**From:** Simon Davis <Simon.Davis@arun.gov.uk>  
**Sent:** 21 July 2020 15:46  
**To:** Planning.Responses <Planning.Responses@arun.gov.uk>  
**Subject:** FW: FW: N of Summer Lane P/62/20/DOC

Further Drainage Engineer comments - P/62/20/DOC

**From:** Laura Gibbons [REDACTED]  
**Sent:** 21 July 2020 13:14  
**To:** Leon Darrell [REDACTED]  
[REDACTED]  
**Subject:** Re: FW: N of Summer Lane P/35/20/DOC & P/37/20/DOC

Drawing Title:-
SuDS FEATURES GENERAL ARRANGEMENT LAYOUT

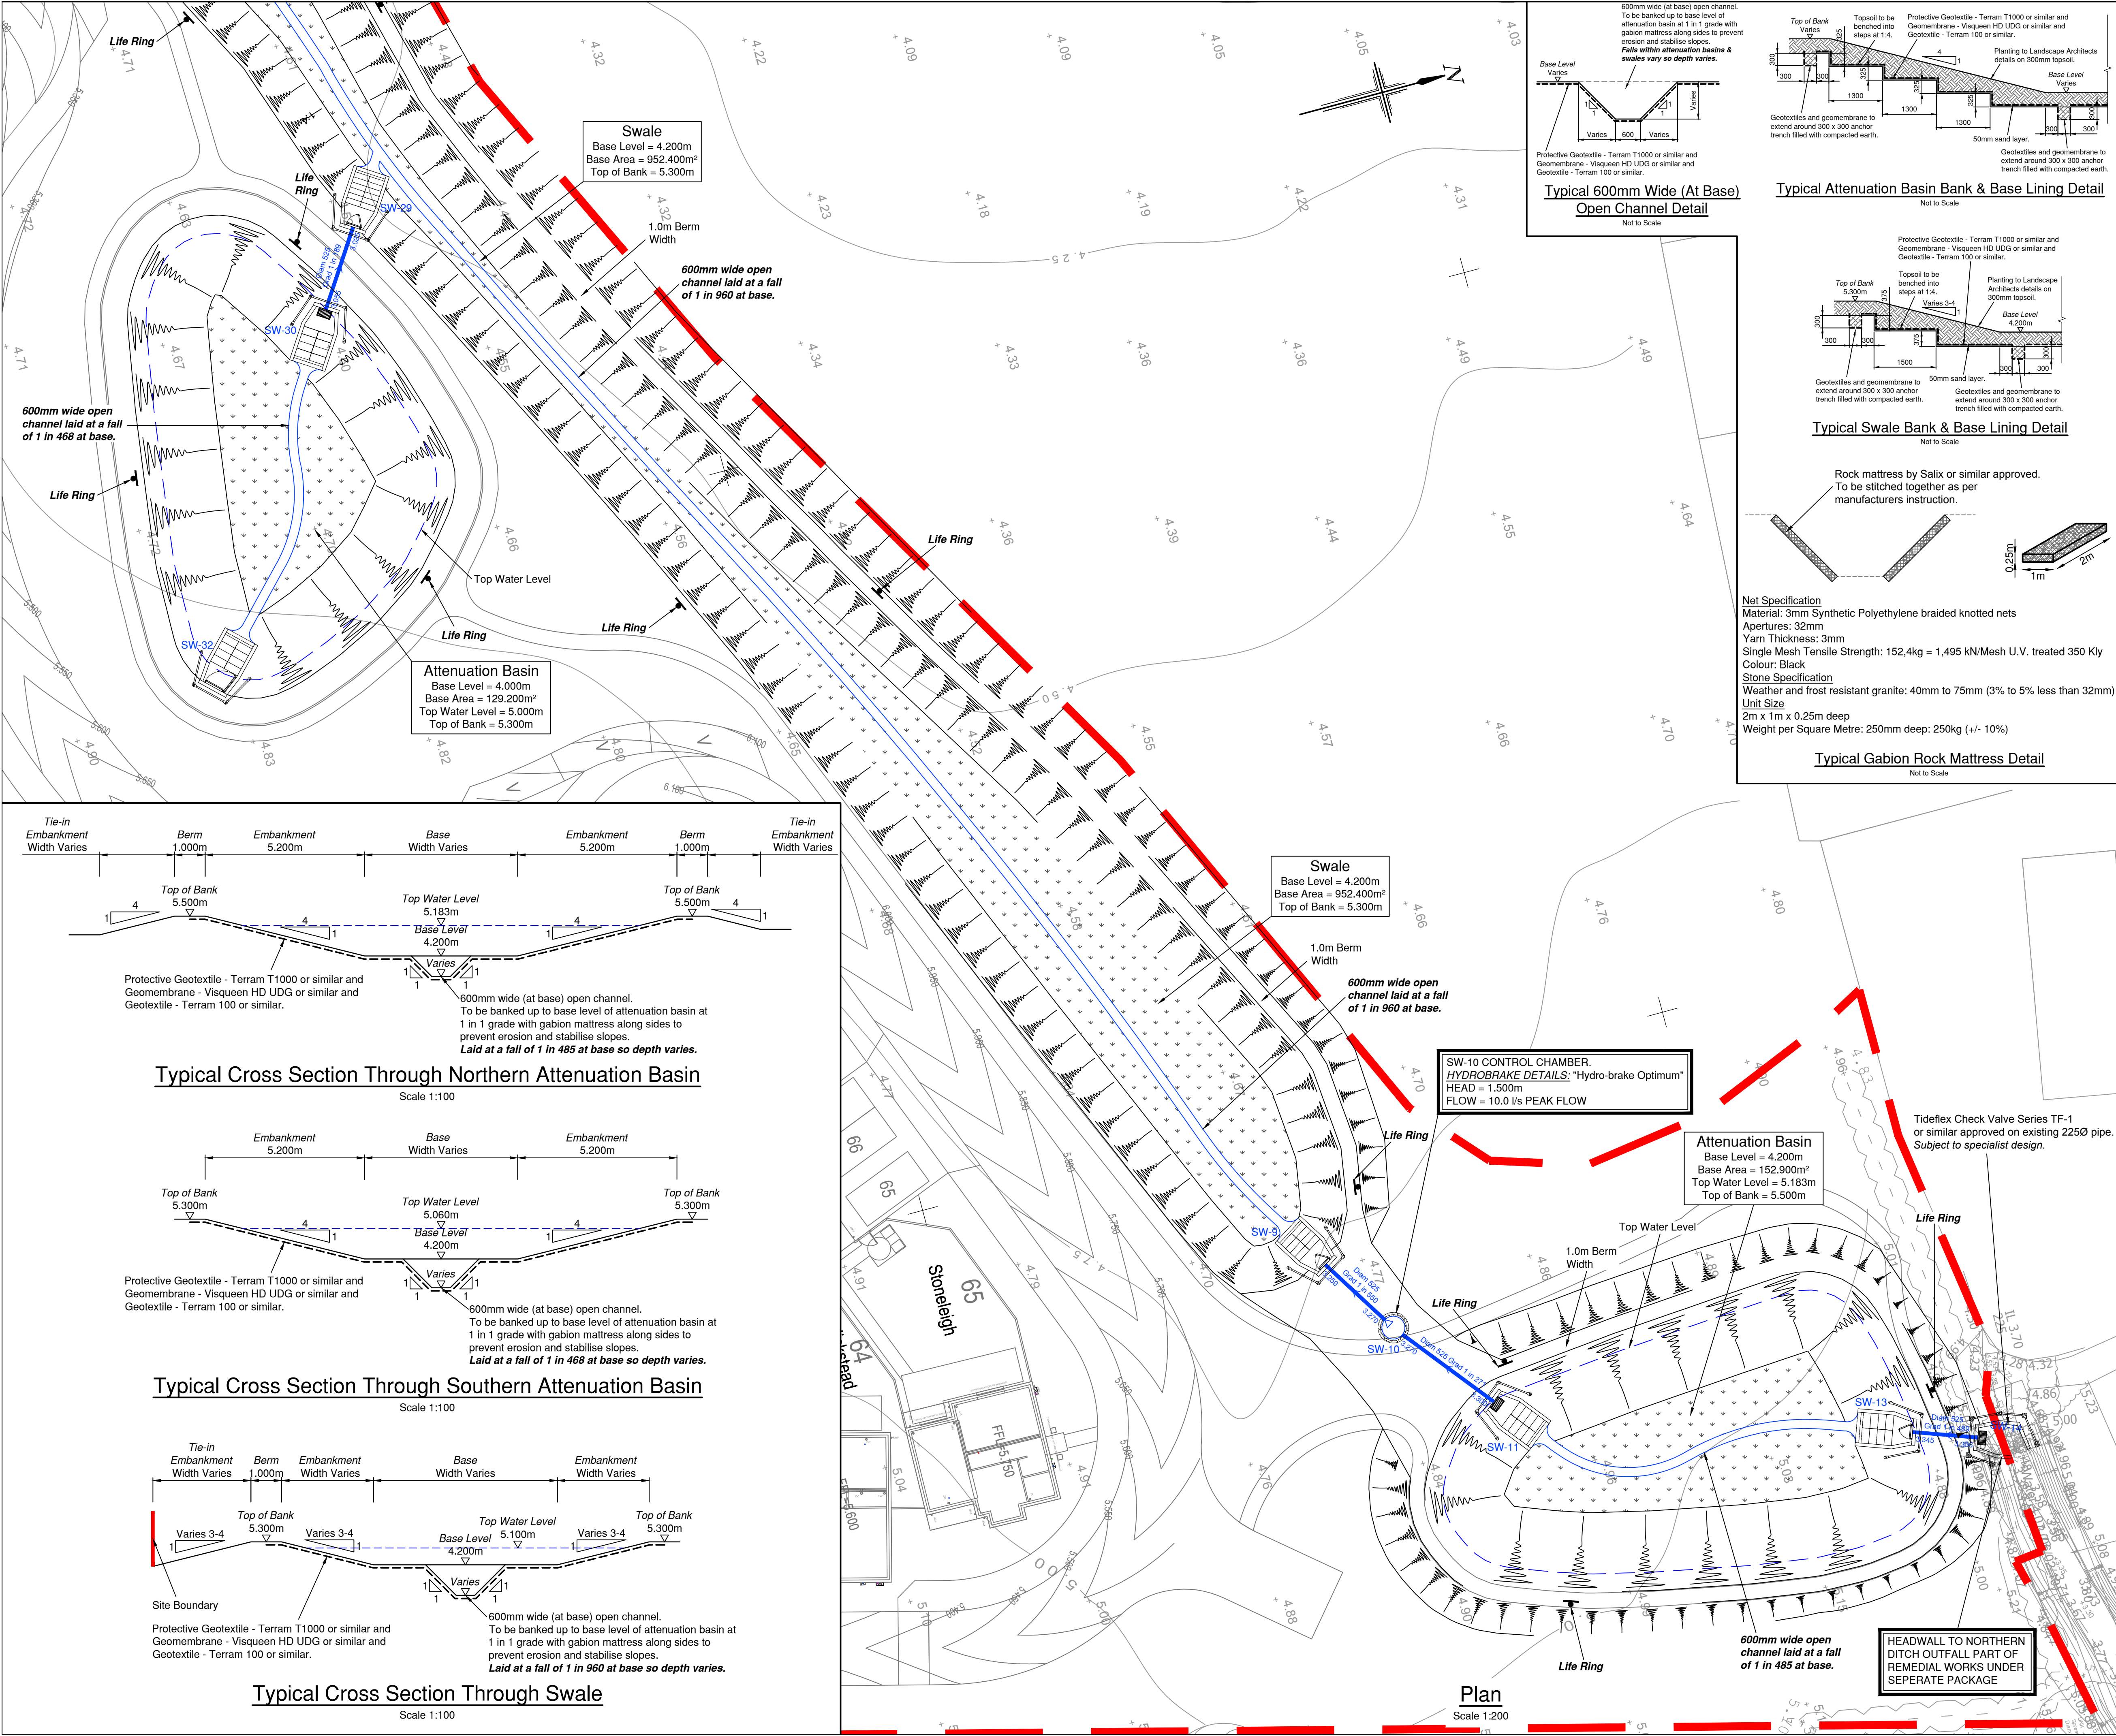
Thanks for sending over the revised information. Could you provide an exceedance flow plan please, including locations of predicted flooding. I note that the top of bank of swale shown on the SuDS layout drawings is 4.95m, but 5.3m on cross sections, please can this be corrected to be consistent.
